**KIRKLEES METROPOLITAN COUNCIL
INVESTMENT & REGENERATION SERVICE**

DELEGATED DECISION TO DETERMINE PLANNING APPLICATIONS

Reference No: 2020/62/90054/W
Site Address: 56, West Street, Lindley, Huddersfield, HD3 3JX
Description: Erection of single storey extension to side and rear
Recommending Officer: Ellie Worth

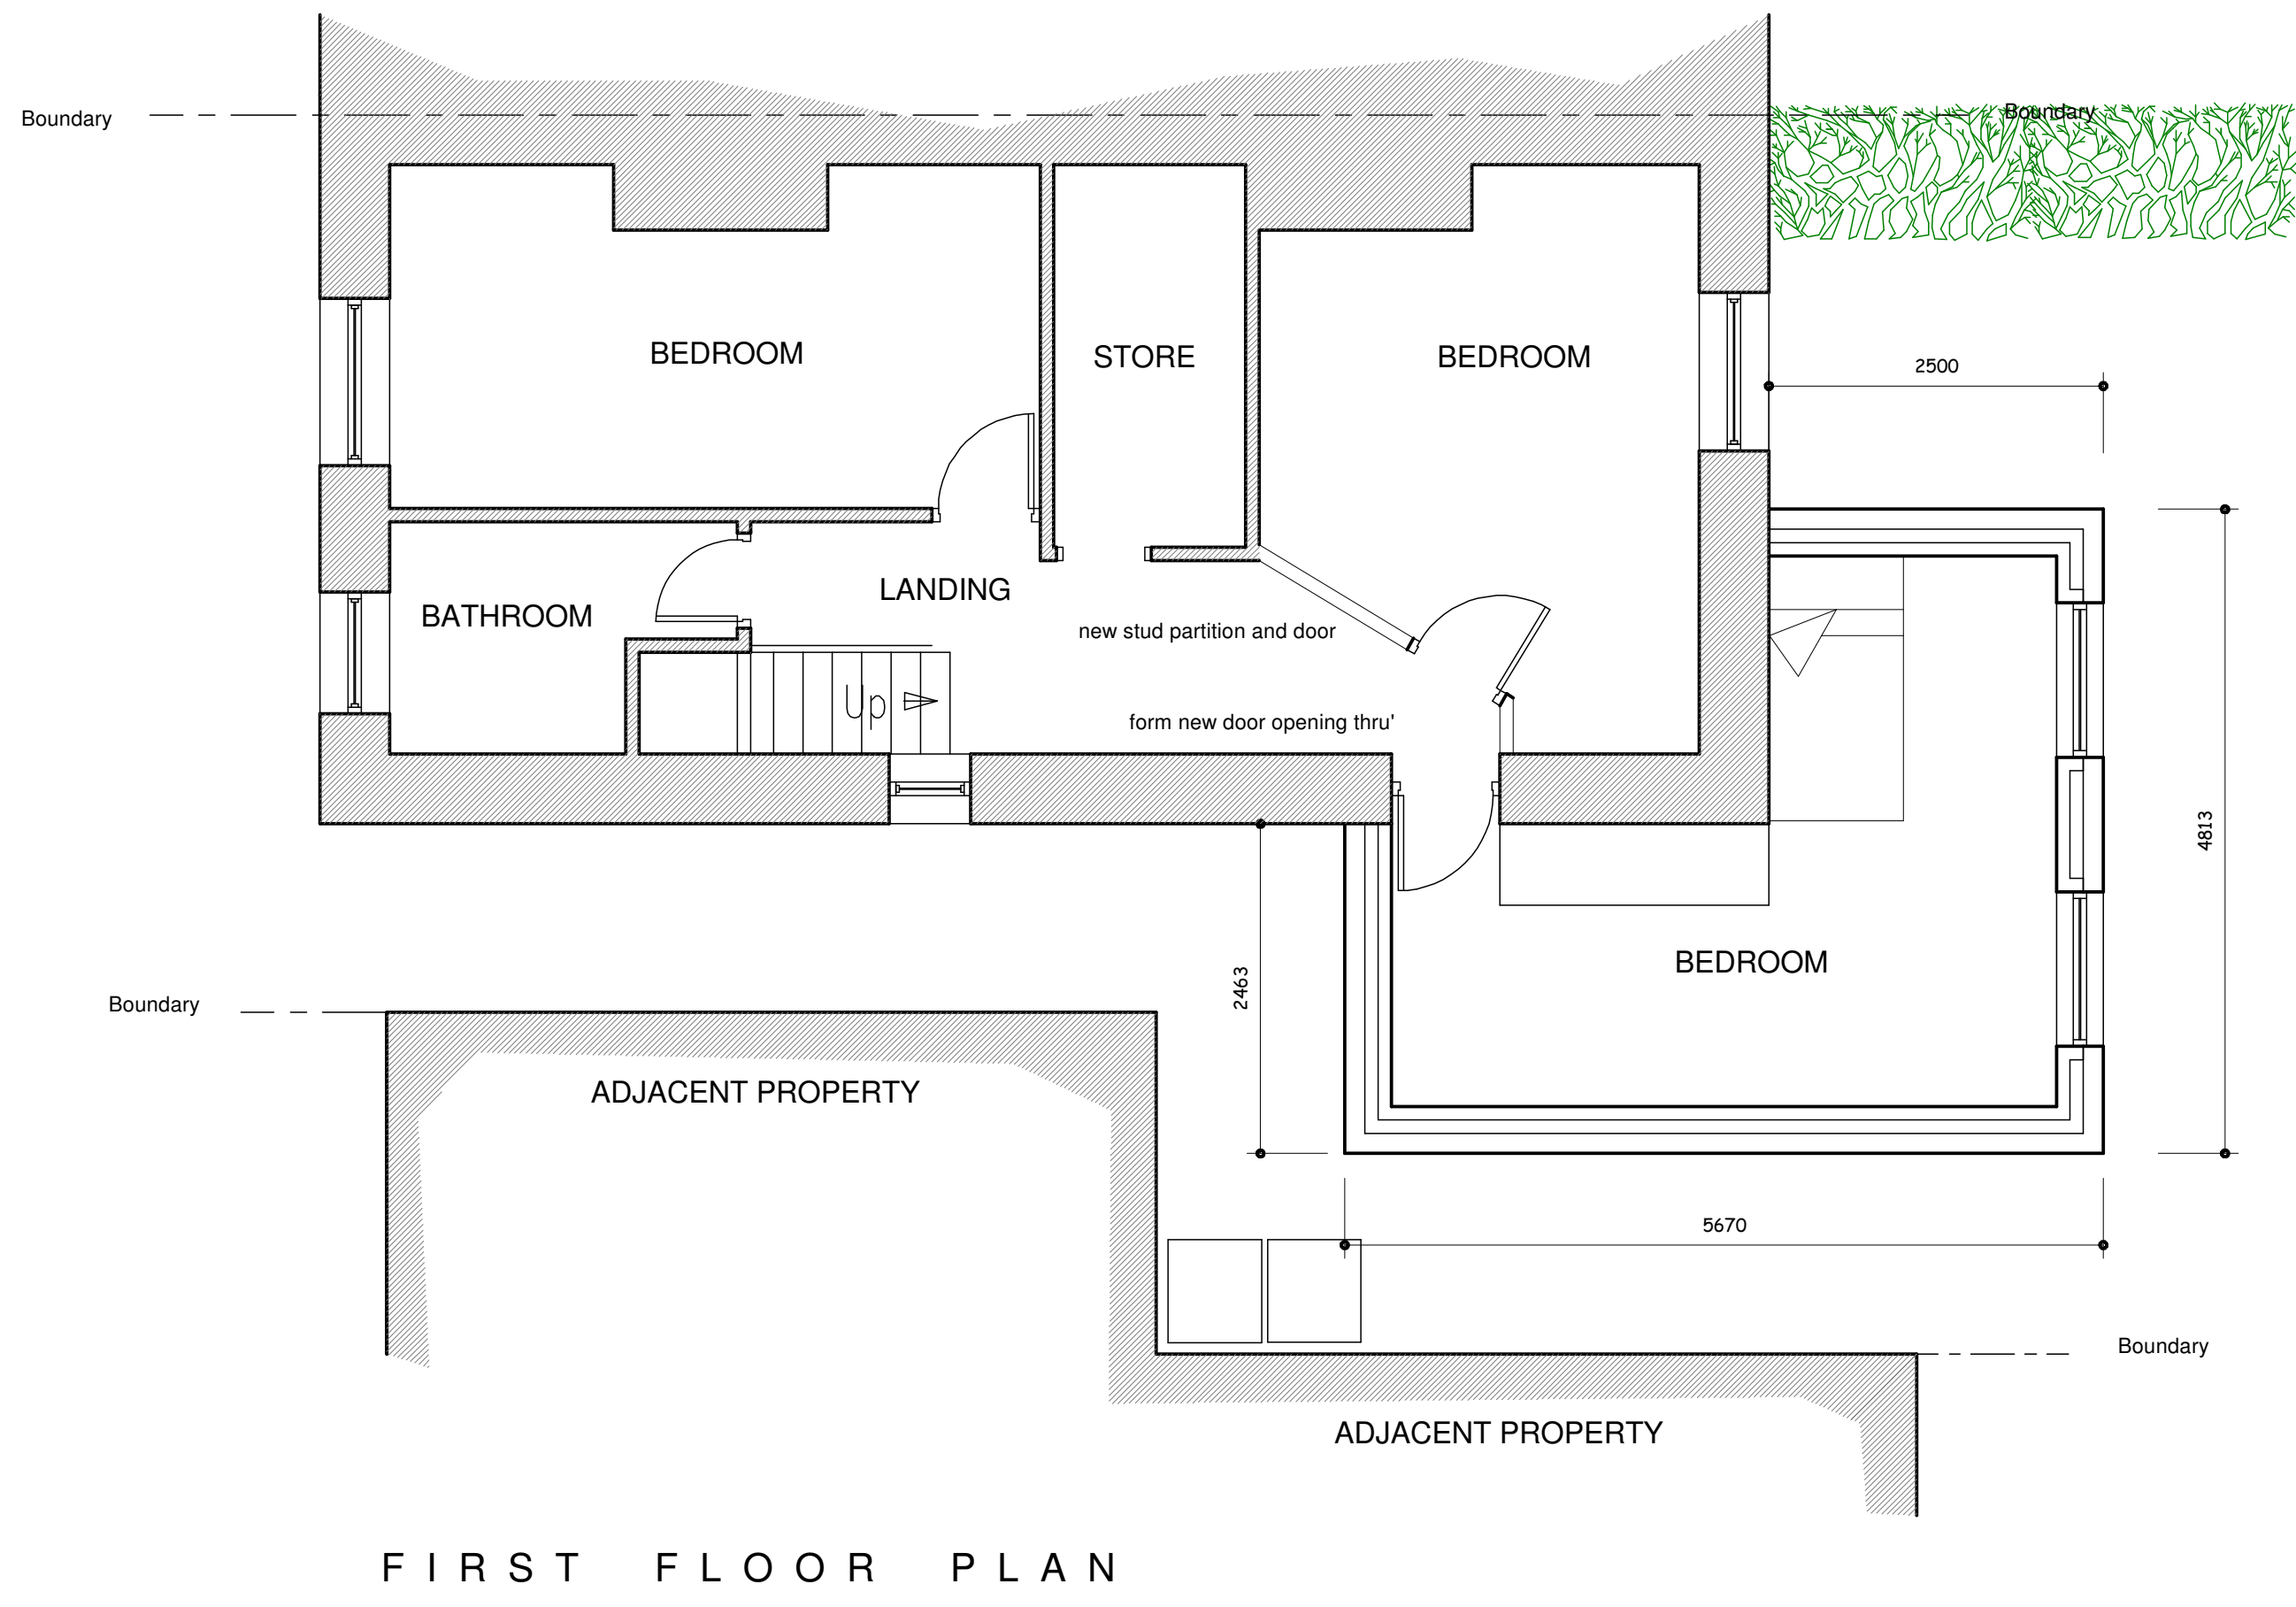
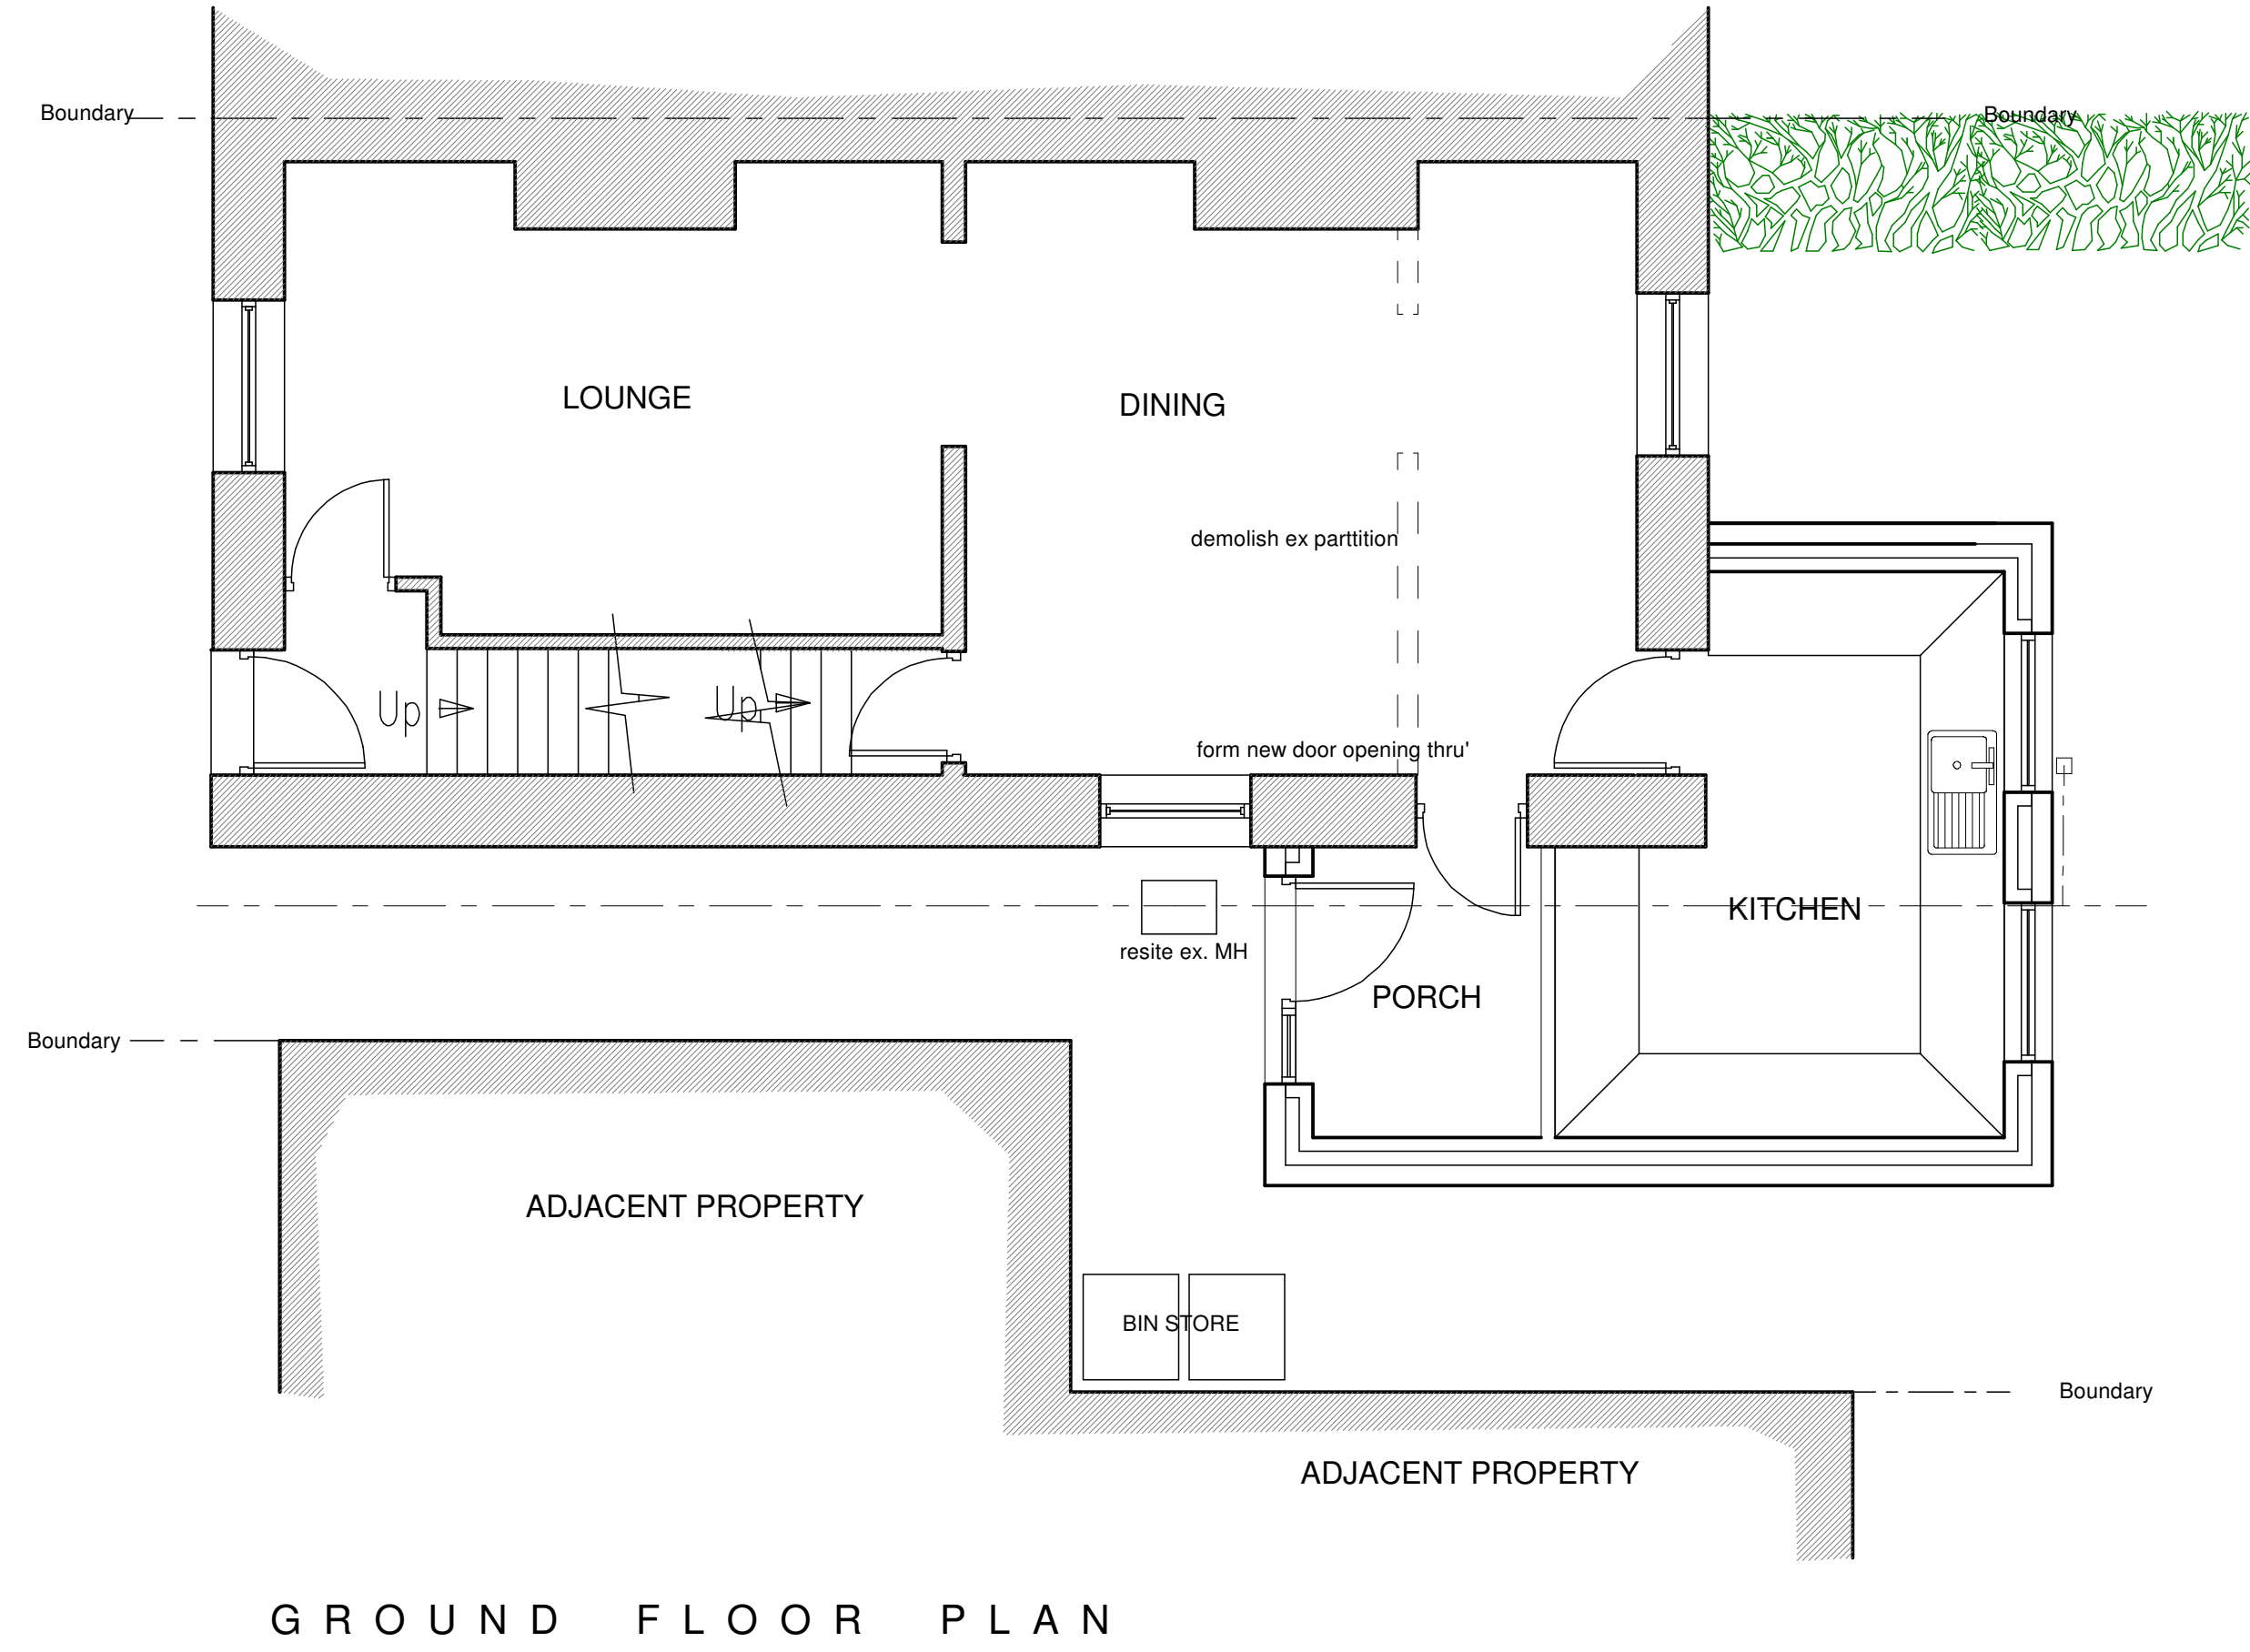
The officer entered into discussions with the agent regarding the overall size and scale of the extension, given its relationship with the host property and the fact that it would be readily visible from public vantage points. As such, amended plans were received on the 2nd March 2020.

In terms of fenestrations, the submitted plans show two openings to be inserted into the northern facing elevation, alongside a smaller opening to serve an en-suite, within the eastern facing side elevation. These would have a satisfactory visual impact, as the openings proposed would be of a similar appearance to those that exist on the host property.

The submitted plans also show no additional openings to be inserted into the western facing side elevation of the extension. Nonetheless, in order to protect the existing and future neighbour's amenity it has been considered necessary to remove future openings within this elevation.

In terms of overlooking, the submitted plans show a small opening to be inserted into the eastern facing side elevation. Given that this will serve a bathroom and is likely to be obscurely glazed no significant concerns is raised. Nonetheless, in order to protect these neighbours' amenity, future openings within the eastern facing side elevation will be removed, as the extension would bring development closer to the shared boundary at these neighbours. As such, a condition will be attached to the decision notice accordingly.

4. Notwithstanding the provisions of the Town and Country Planning (General Permitted Development) (England) Order 2015 as amended (or any Order revoking or re-enacting that Order) no doors, windows or any other openings, other than those expressly permitted by this development, shall be created within the eastern and western side elevations of the extension hereby approved.
